Our ref: HA/2011/111195/01-L01
Your ref: LU/386/10/
Date: 01 February 2011

**NEW BUILD SINGLE STOREY DWELLING
SEANORMUS, ROPE WALK, LITTLEHAMPTON, WEST SUSSEX BN17 5DE**

Environment Agency position

Title PROPOSED FLOOR
AND ROOF PLAN

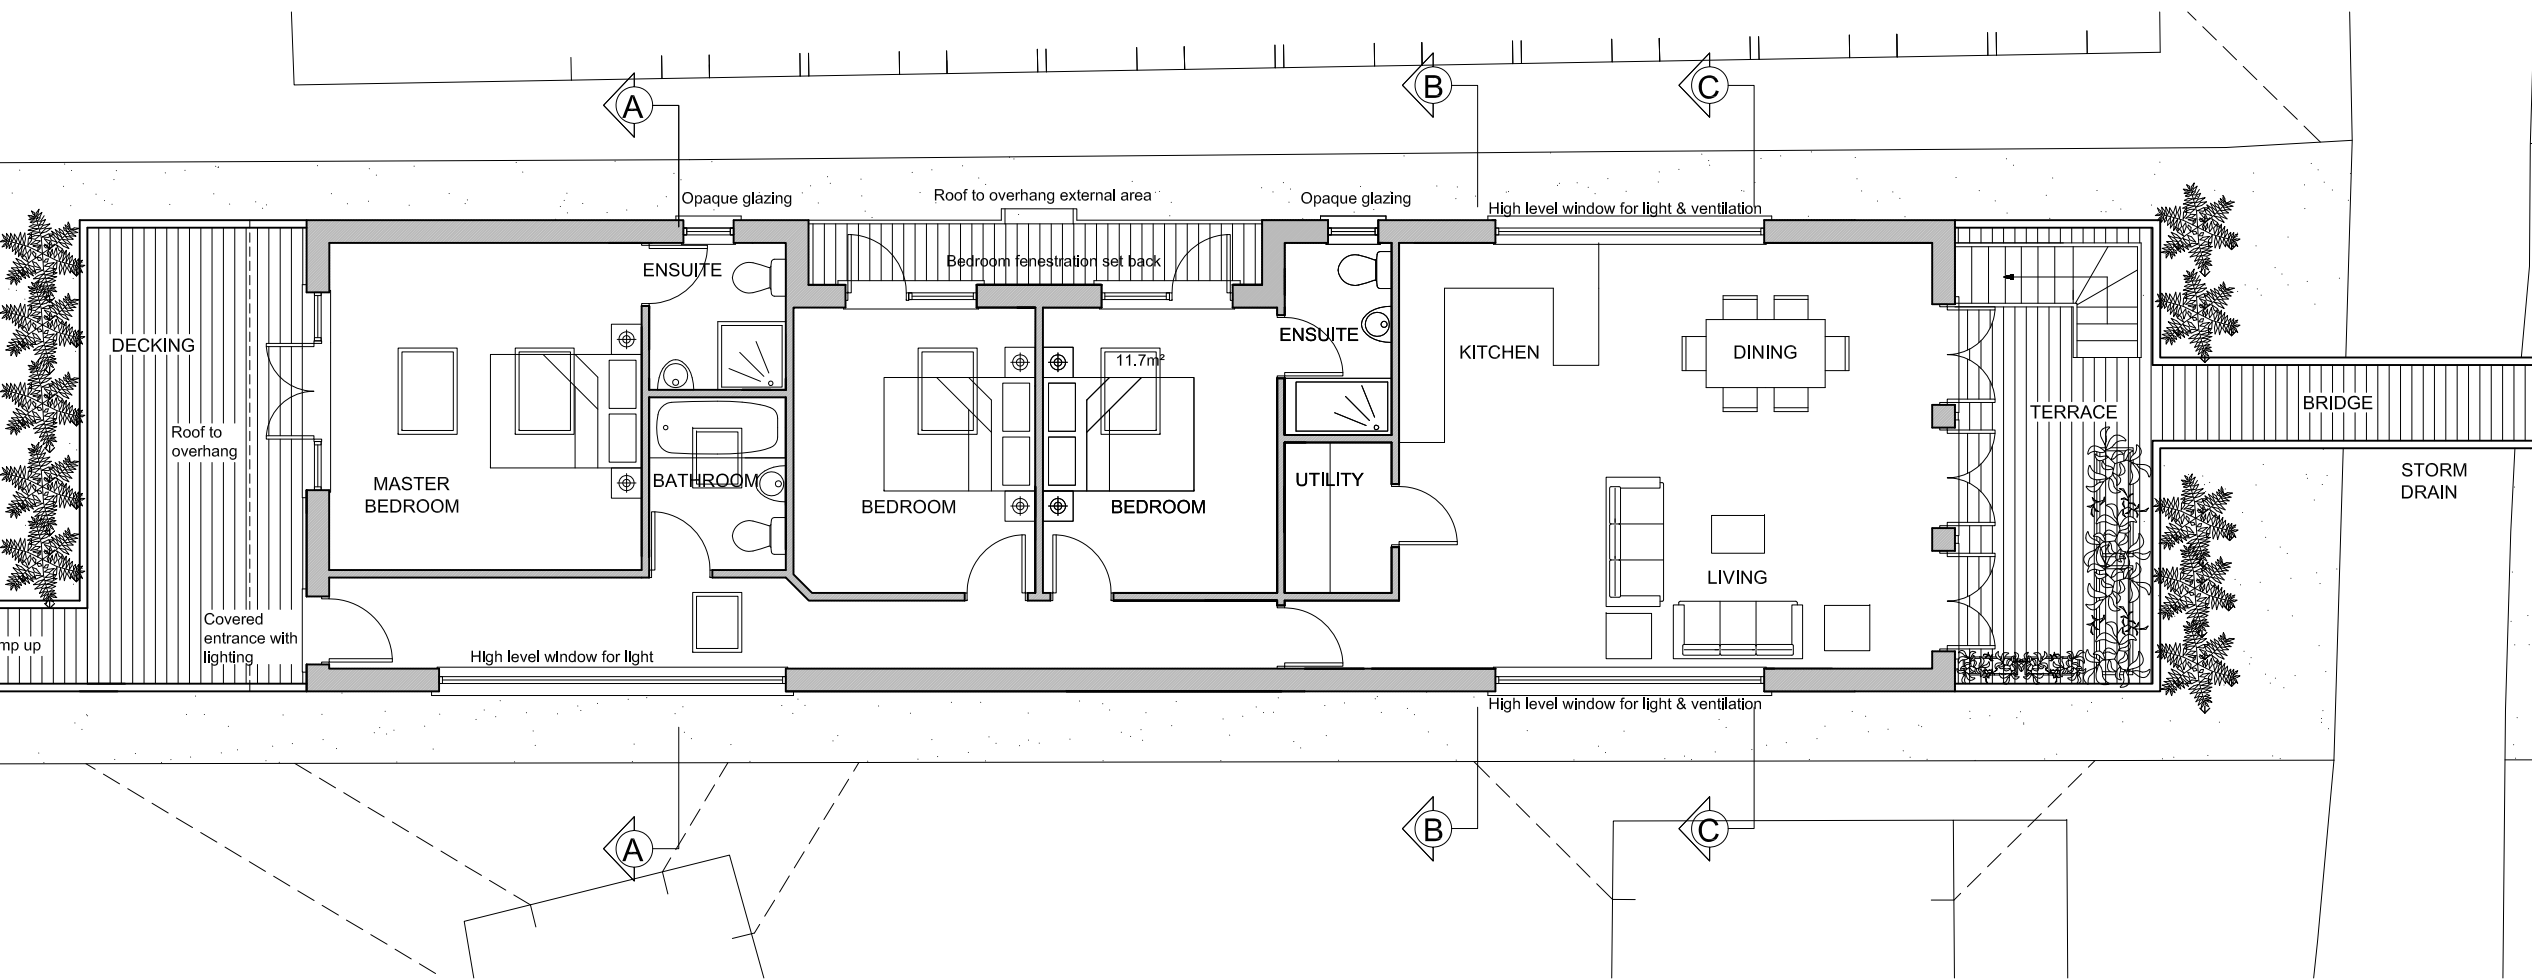
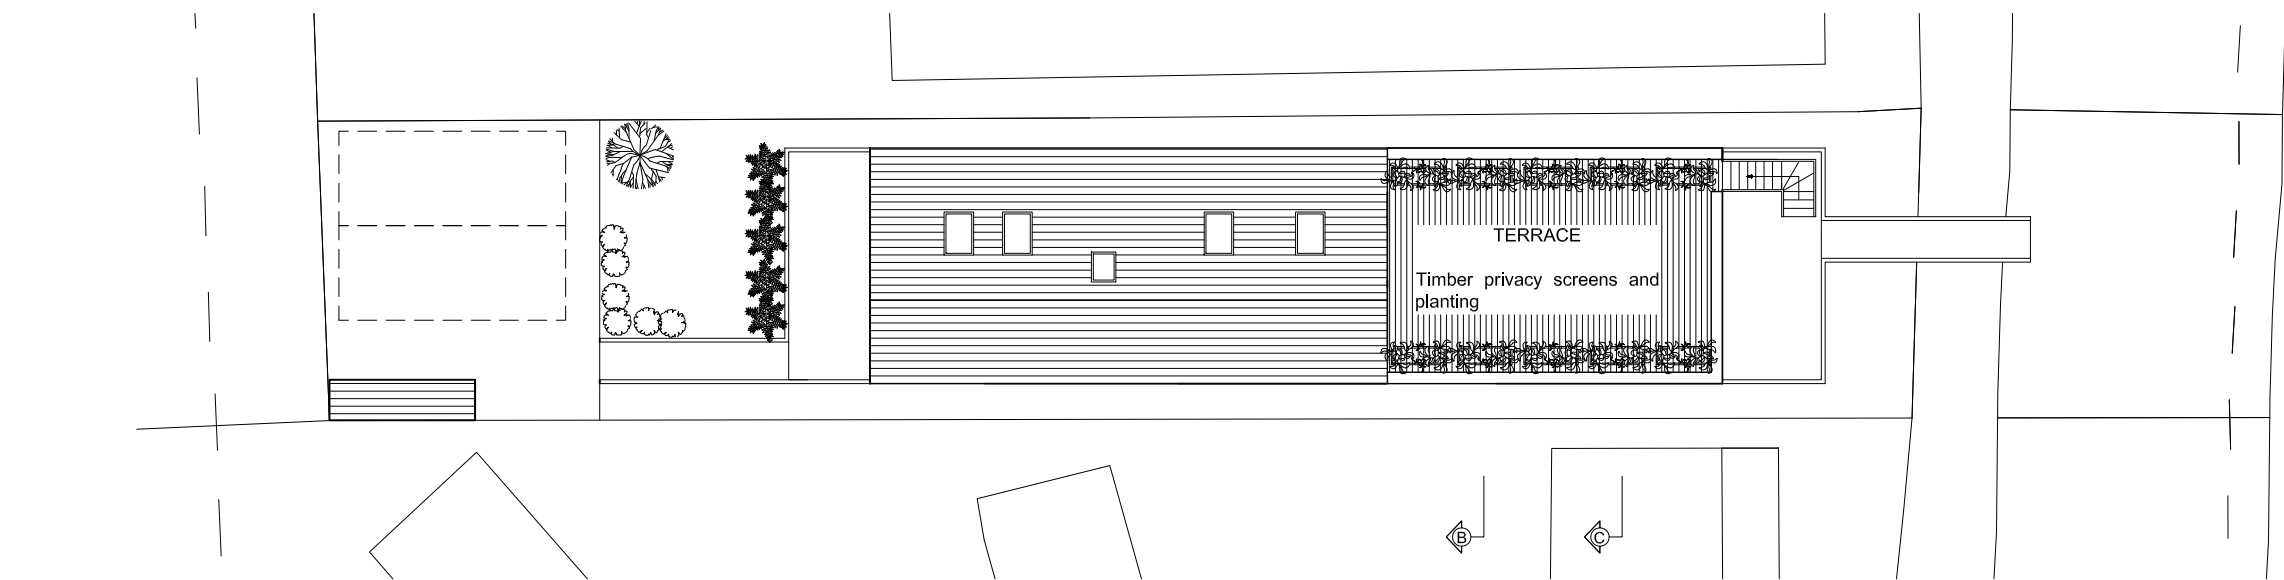
The proposal is for a single storey dwelling, with habitable rooms on the ground floor. In the design flood event, no safe access or egress would be possible, and no safe refuge within the dwelling is offered.
